Subject: FW: Planning Consultation on AL/20/19/DOC

Comment from Greenspace

The information supplied in Dwg BG.8.03.M sets out the planting for the site, but it is a little unclear which is existing and which is the new proposed planting as part of this application.

BOGNOR
BG.8.03.M

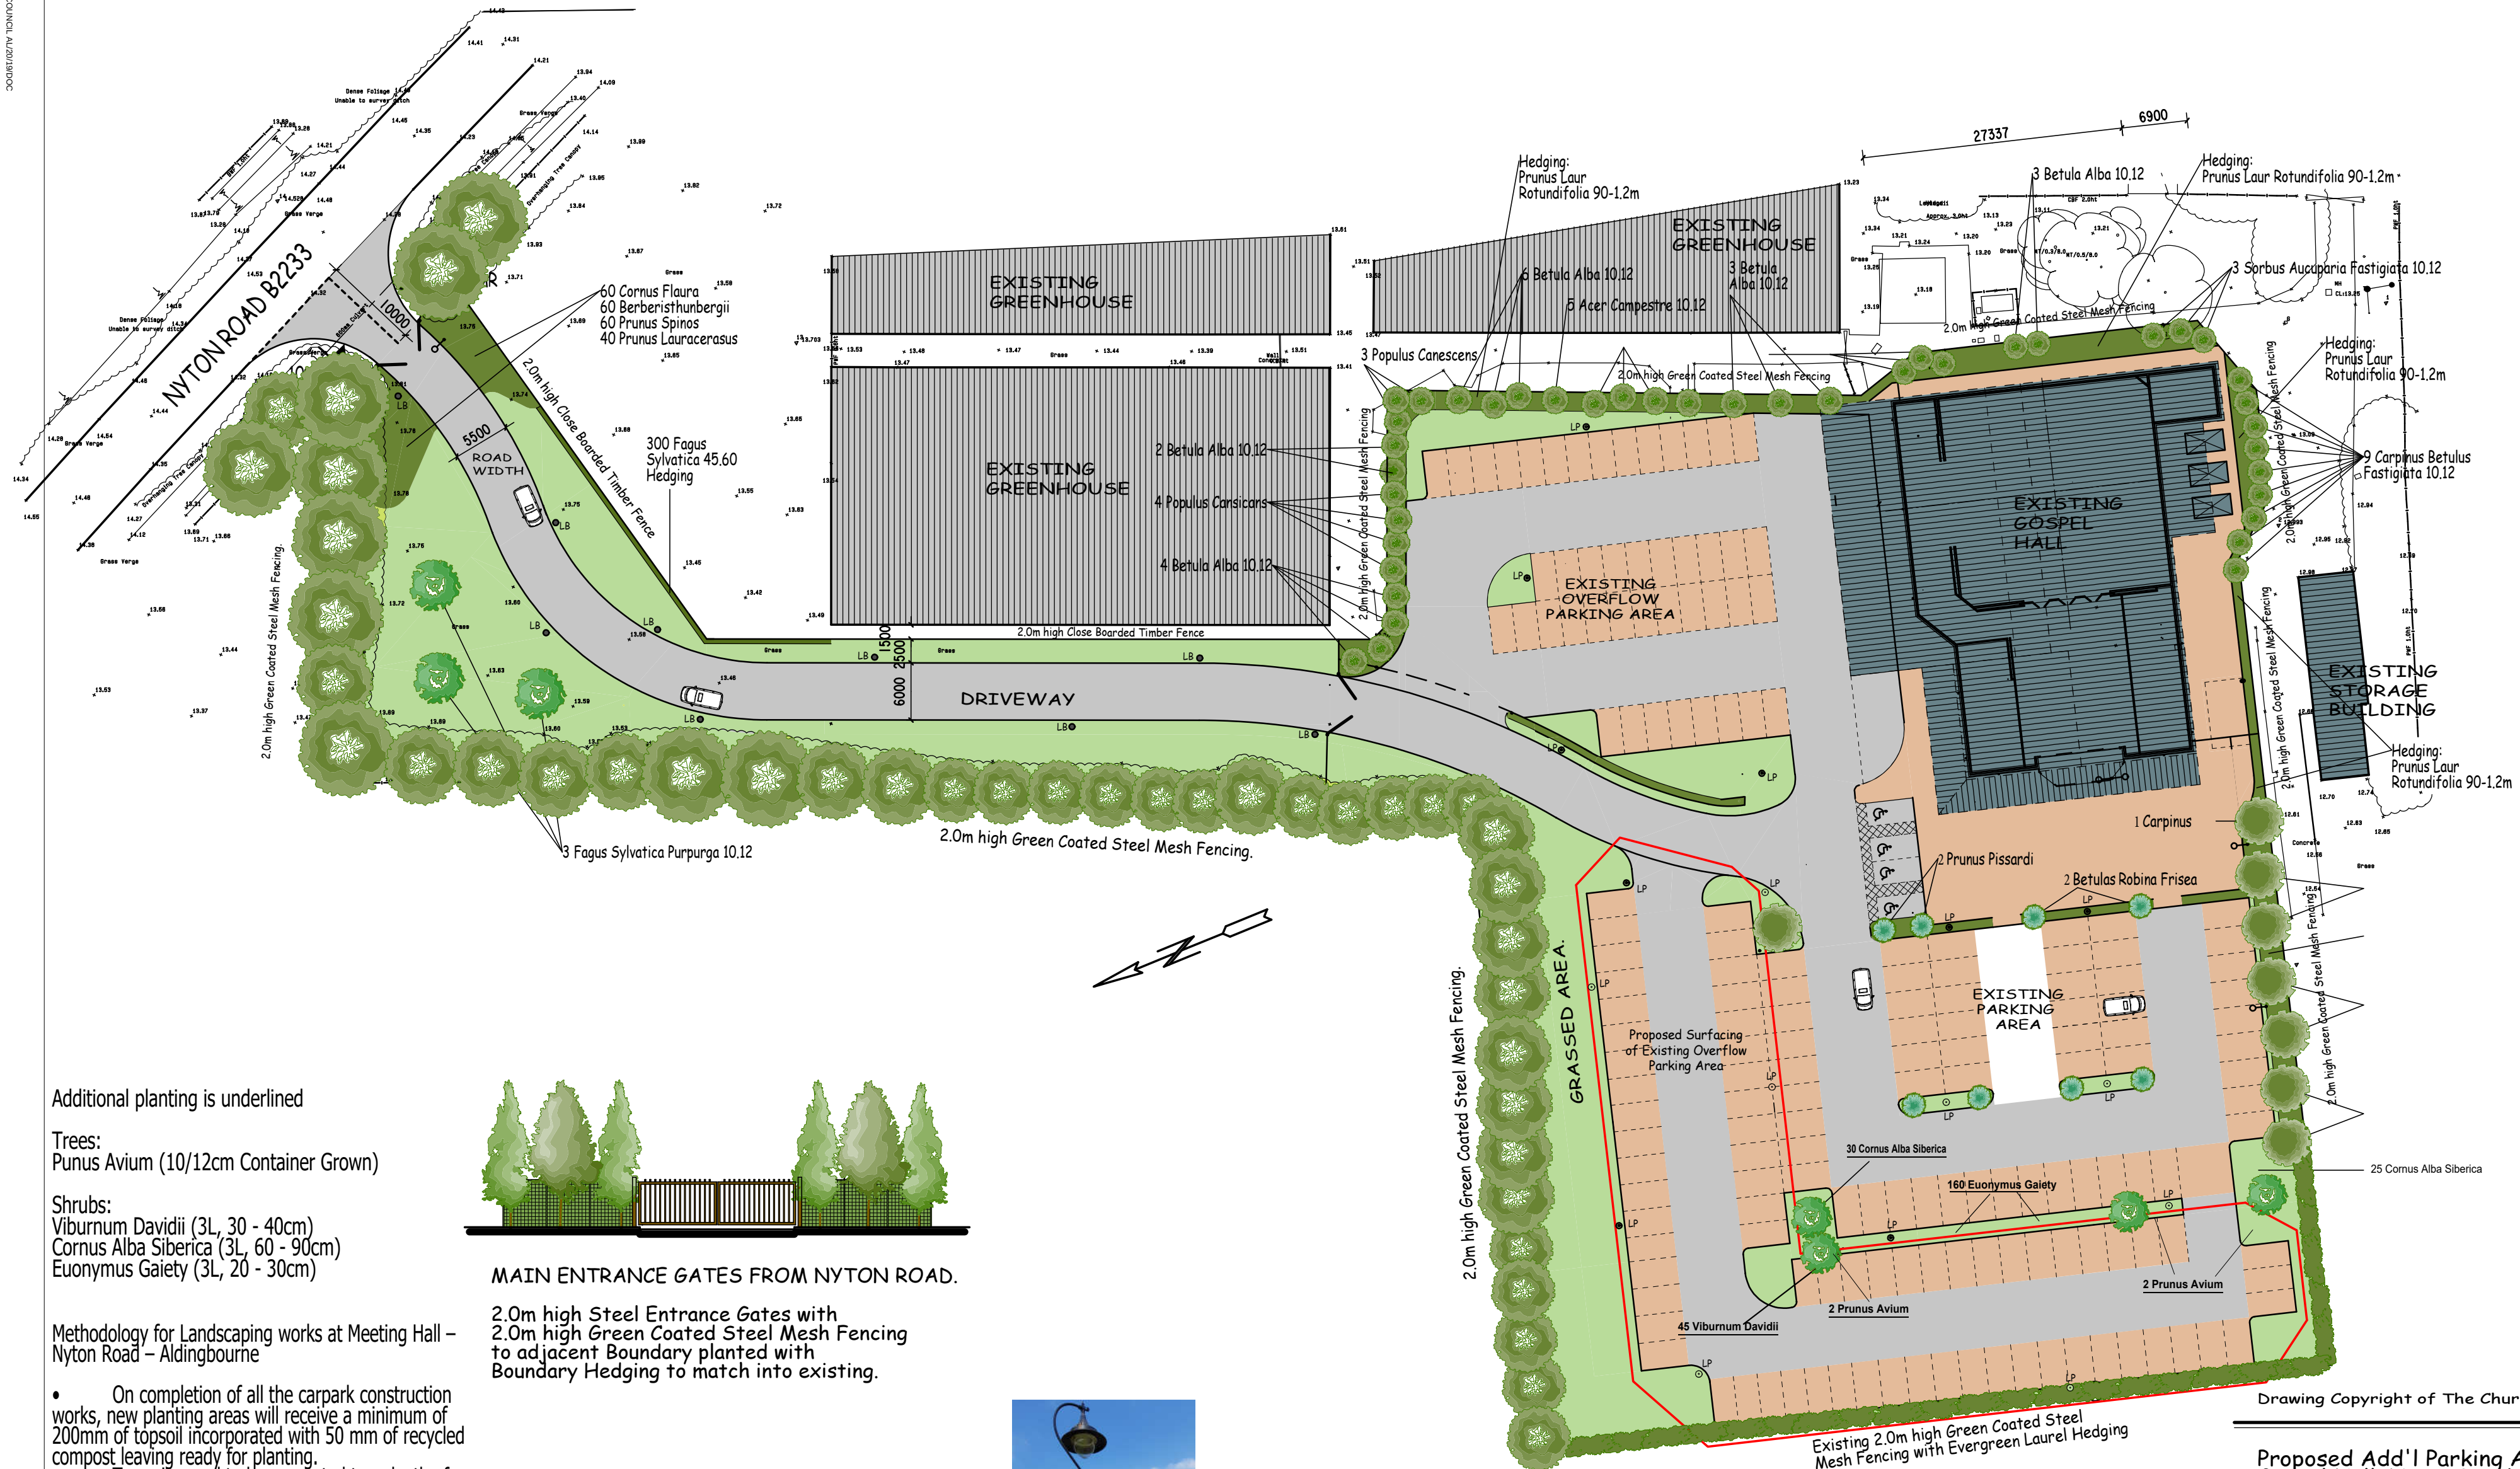
I would recommend that further detail is provided to highlight which is the new planting with a detailed schedule also of quantities, species choice and size at time of planting.

I would recommend that this information is submitted for approval before Condition 4 on AL/20/19/DOC could be considered for discharge.
